PLANNING AMENDMENT

WESTON VILLAGE HALL
STEERING COMMITTEE

WESTON ST. MARY PRIMARY SCHOOL PLAYING FIELD

SITE FOR CONSTRUCTION OF A
NEW VILLAGE HALL

SITE PLAN SHOWING LOCATION OF BUILDING & CP

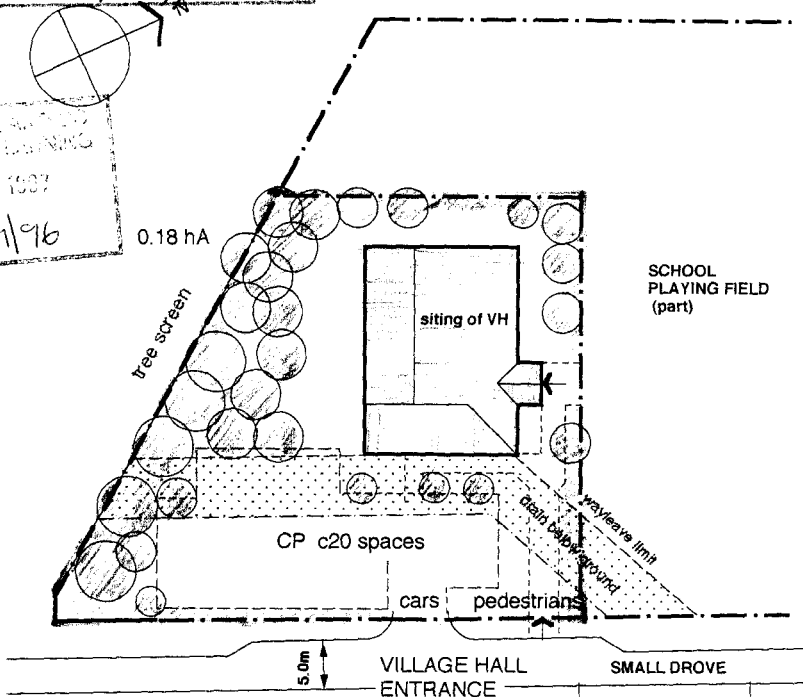
RETHAPING OF SITE BOUNDARY
AND RELOCATION OF LOCATION OF
HALL AND CAR PARK

NO NUMBER / ENTITLED "REVISED PRELIM.
STUDY FOR LOCATION OF BLDG."
